ORIEL WIND FARM PROJECT

Environmental Impact Assessment Report – Addendum
Chapter 27 Addendum: Seascape, Landscape and Visual Amenity

MDR1520C
EIAR – Chapter 27 Addendum
A1 C01
December 2025

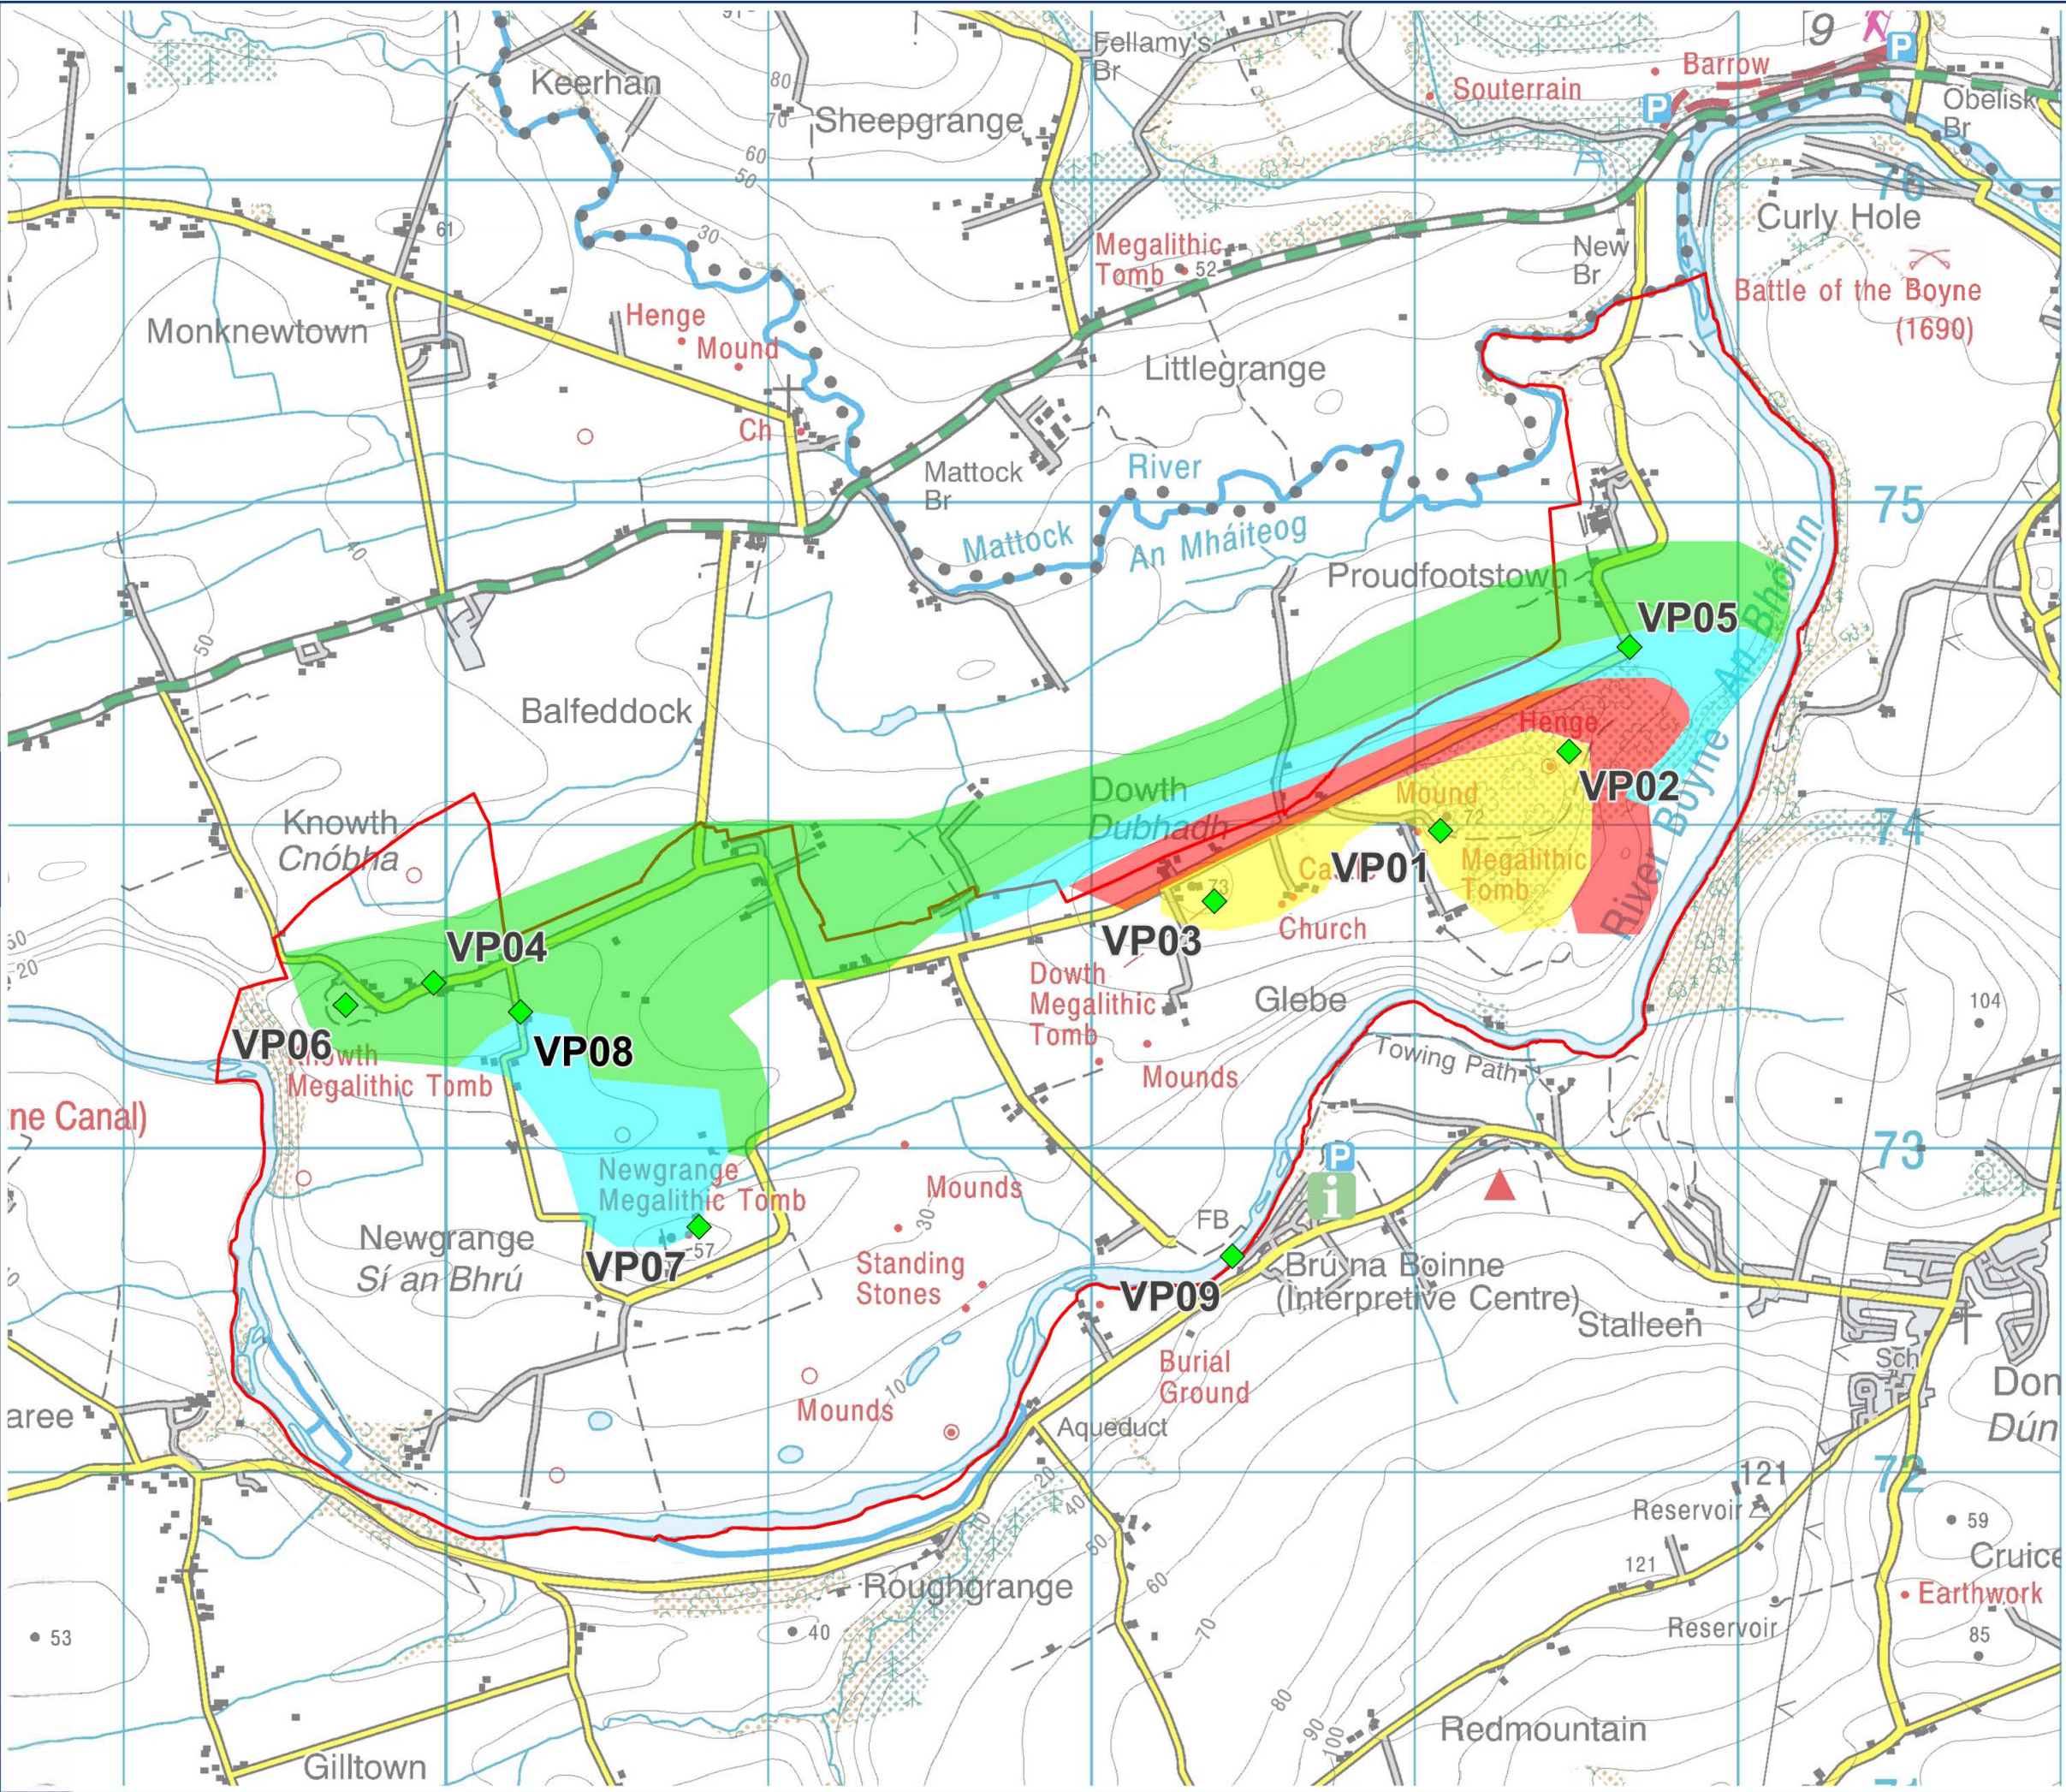
Reference	Request for Further Information	Response / Reference to where information is presented	Concluding statement
12.A	<p>The Board acknowledges the comprehensive visual impact assessment undertaken in support of the project. However, the applicant is invited to address the concerns raised by Meath County Council in terms of the potential visual impacts associated with the project on views to and from historic sites including the Bru an Boinne World Heritage Sites, approximately 28.5km from the offshore array area. Having regard to the sites UNESCO⁶ World Heritage Site designation, recognised for its Outstanding Universal Value (OUV), the applicant is requested to assess the proposed development having regard to the World Heritage Convention UNESCO Guidance Notes as they relate to visual impact assessment and wind energy projects, including 'Guidance and Toolkit for Impact Assessments in a World Heritage Context' (UNESCO, 2022), 'Guidance for Wind Energy Projects in a World Heritage Context' (UNESCO, 2023), and available UNESCO case studies relating to the assessment of offshore projects on World Heritage sites.</p> <p>6 - United Nations Educational, Scientific and Cultural Organisation</p>	<p>The Applicant's response to the concerns raised by Meath County Council (MCC) is included in the Response to Submissions Report.</p> <p>In relation to MCC's concerns regarding potential impacts on the Brú na Bóinne World Heritage Site (WHS), section 27.10.3 and Table 27A-3 in this Addendum provide an assessment of the indirect landscape effects of the Project on the WHS.</p> <p>Also, section 27.10.5 and Table 27A-4 to Table 27A-13 inclusive provide an assessment of the visual impacts of the Project on nine of viewpoints from within the WHS.</p> <p>Appendix 27-2: World Heritage Site Assessment provides an assessment of the Project's potential impact on the OUV.</p>	<p>An assessment of the Brú na Bóinne WHS was screened out of the Cultural heritage setting assessment included in chapter 26: Cultural Heritage (EIAR volume 2C) as there was minimal visibility from the WHS due to the distance, vegetation, and intervening landform.</p> <p>Applying the UNESCO Guidance and Toolkit for Impact Assessments in a World Heritage Context⁷ (UNESCO, 2022) methodology, the assessment demonstrated that the magnitude of change to the OUV is <i>none</i>; the significance of effect on OUV is <i>no impact</i>. No change arises to the setting, integrity, or perception of the monuments or their skyline; the OUV attribute of the WHS comprising 'views into and out of the property' remains intact. The sea horizon lies well beyond the visual and perceptual range of these attributes; it does not contribute to or frame the OUV. The proposed offshore wind farm lies far beyond the skyline features referenced in the UNESCO statement of OUV and will not introduce any new element perceptible from the property; therefore, it will not alter the character of the wider setting or adversely affect the OUV. There will be no significant individual or cumulative visual impact on the OUV of the WHS.</p>

In response to RFI 12.A. regarding the concerns raised by MCC, an extract from the Project 60 km Zone of Theoretical Visibility (ZTV) mapping has been provided as Figure 27A-10d in appendix 27-1 Addendum: Seascapes, Landscape and Visual Amenity Accompanying Graphics to show the ZTV at Brú na Bóinne WHS.

The ZTV analysis indicates that a central portion of the Brú na Bóinne WHS is predicted to experience variable, theoretical visibility of the Project. Theoretical visibility banding indicates that most of the predicted visibility is associated with theoretical visibility of 1 to 6 turbines, with a smaller area predicted to experience theoretical visibility of between 19 and 25 turbines associated with the Project. Remaining portions of predicted theoretical visibility is variable and scattered, with visibility of 7 to 18 turbines theoretically visible within the WHS. Figure 27A-10d also illustrates that large portions of the WHS will not receive any visibility of the Project. Areas of predicted visibility are based on a bare earth scenario, with the ZTV not taking into consideration any screening provided by intervening built form or vegetation cover such as woodlands and tree lined hedgerows.
